KIRKLEES METROPOLITAN COUNCIL INVESTMENT & REGENERATION SERVICE

DELEGATED DECISION TO DETERMINE APPLICATIONS FOR CONSENT, AGREEMENT OR APPROVAL REQUIRED BY CONDITION

Reference No:	2025/44/92839/W
Site Address:	41, Ashbrow Road, Fartown, Huddersfield, HD2 1DX
Description:	Discharge of details reserved by condition 14 (on-site micro-generation) on previous permission 2022/90852 for erection of mixed use development of retreat building and 5 dwellings with integral garages
Recommending Officer:	Danielle Cooper

Officer Report

SITE LAYOUT PLAN

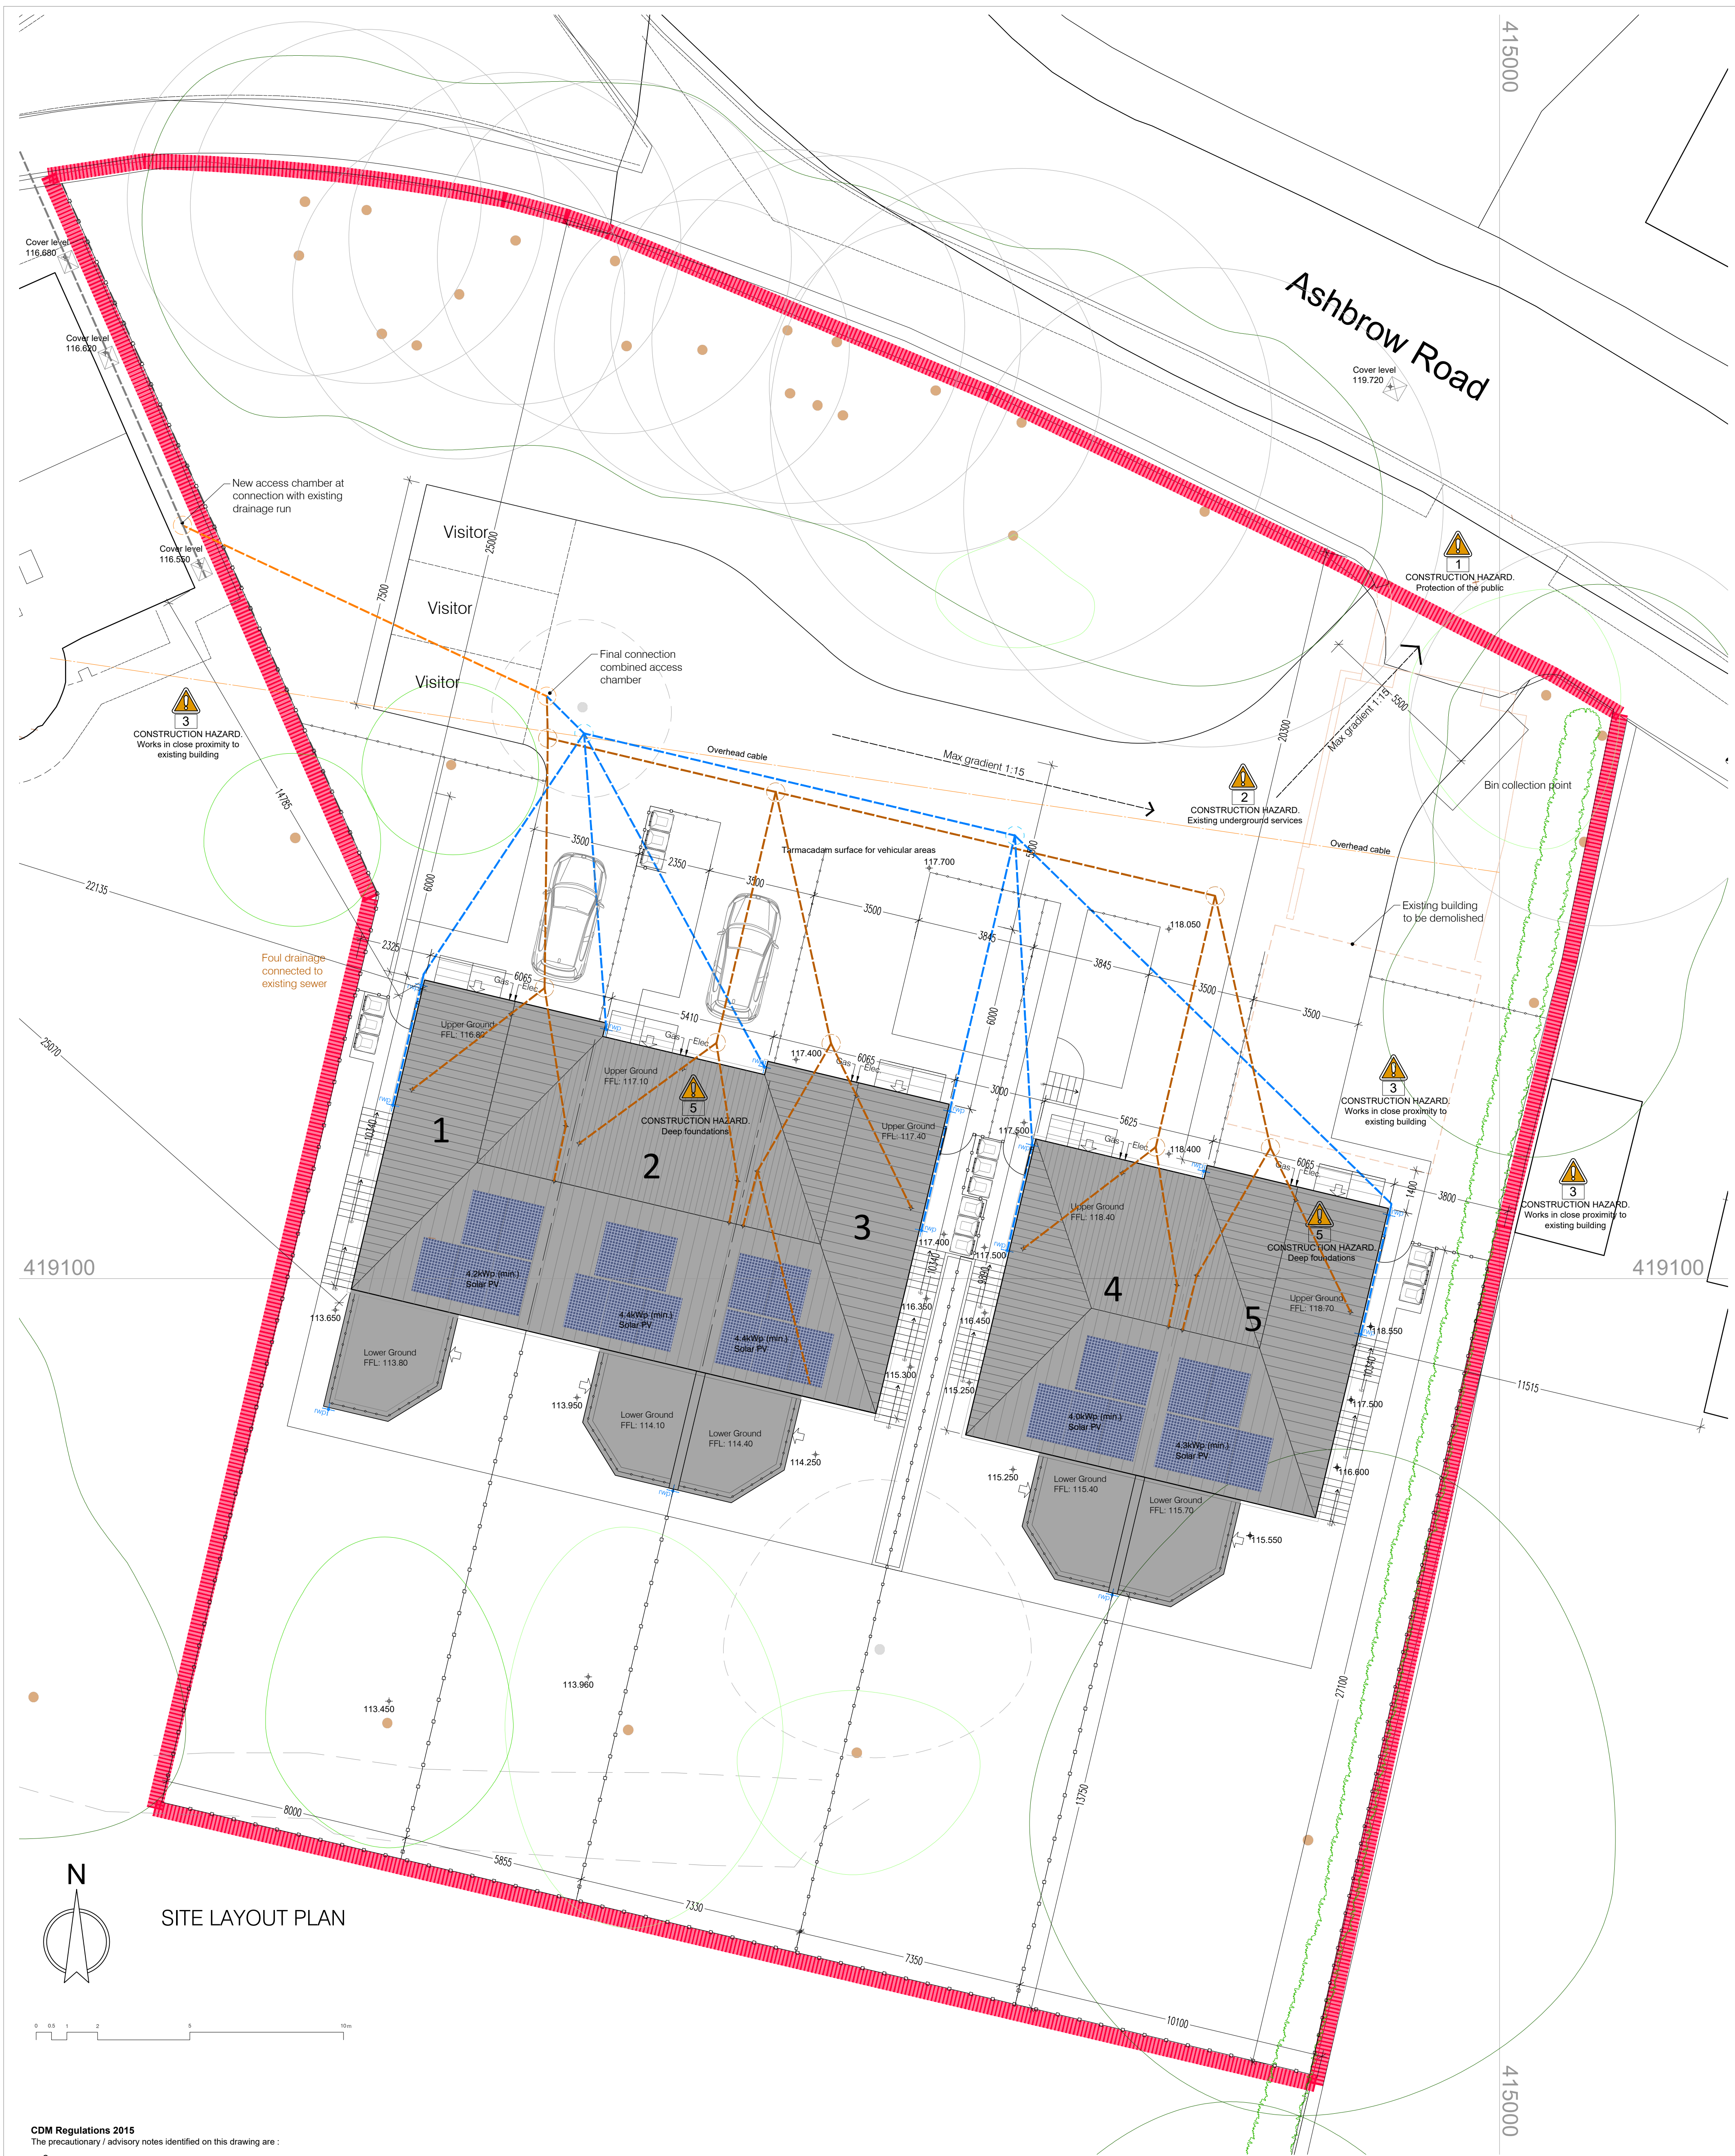
The proposal would see the use of insulation to walls, lofts / voids and would see the use of solar panels to all roof slopes of the dwellings. This would see a total of 25 solar panels provided. Five solar panels are annotated as being 4.2KWP (12 to 16 kWh (kilowatt-hours) per day on average). This would see a large proportion of the electricity consumption of each dwelling addressed by the solar panel installation upon each dwelling.

The extent of the carbon reducing technologies proposed and insulation to be installed to the walls and roof voids of the development is considered acceptable as a scheme to satisfy condition no.14 and the proposal is therefore recommended for approval.
